# CITY OF ALBUQUERQUE

March 10, 2022

**Re: Pascetti Steel Building  
2114 Claremont Ave. NE  
60-Day Temporary Certificate of Occupancy  
Transportation Development Final Inspection**  
Engineer's Stamp dated 8-10-20 (H16-D021)  
Certification dated 3-4-22

SHEET NO:
A1.1

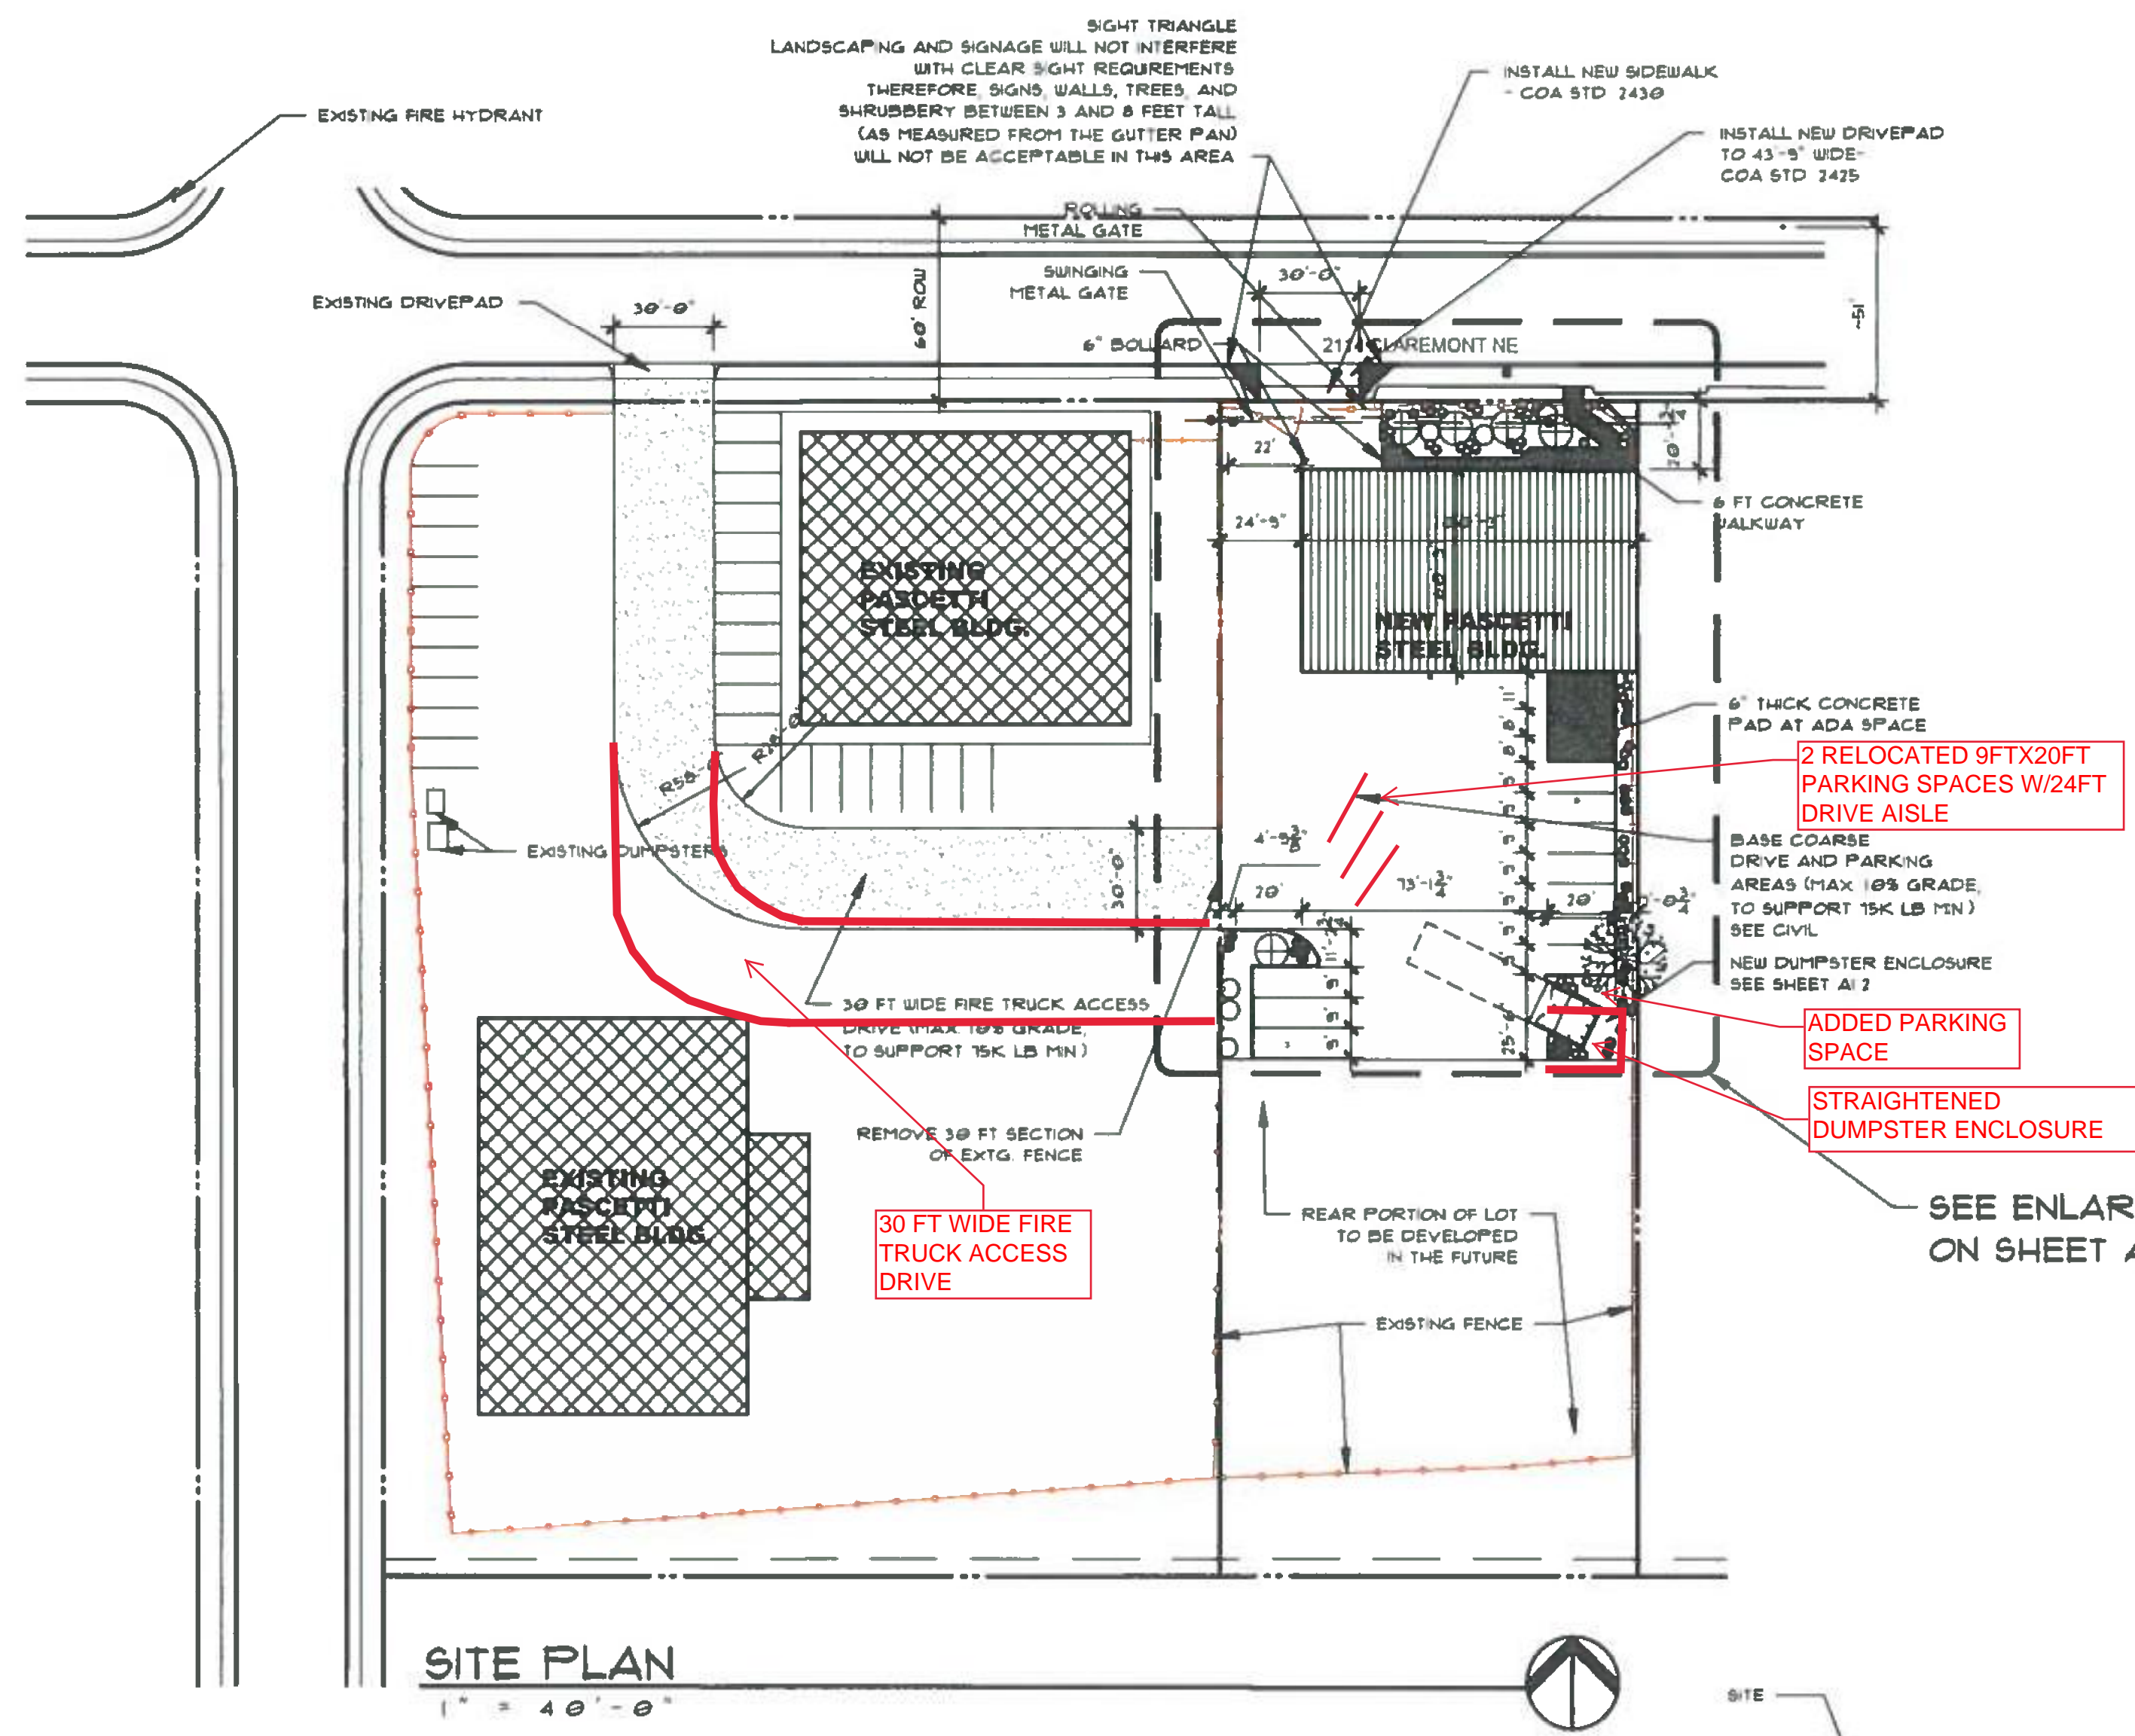
- Parking area must be built per Approved site plan.
- ADA parking spaces must be built per Approved site plan.
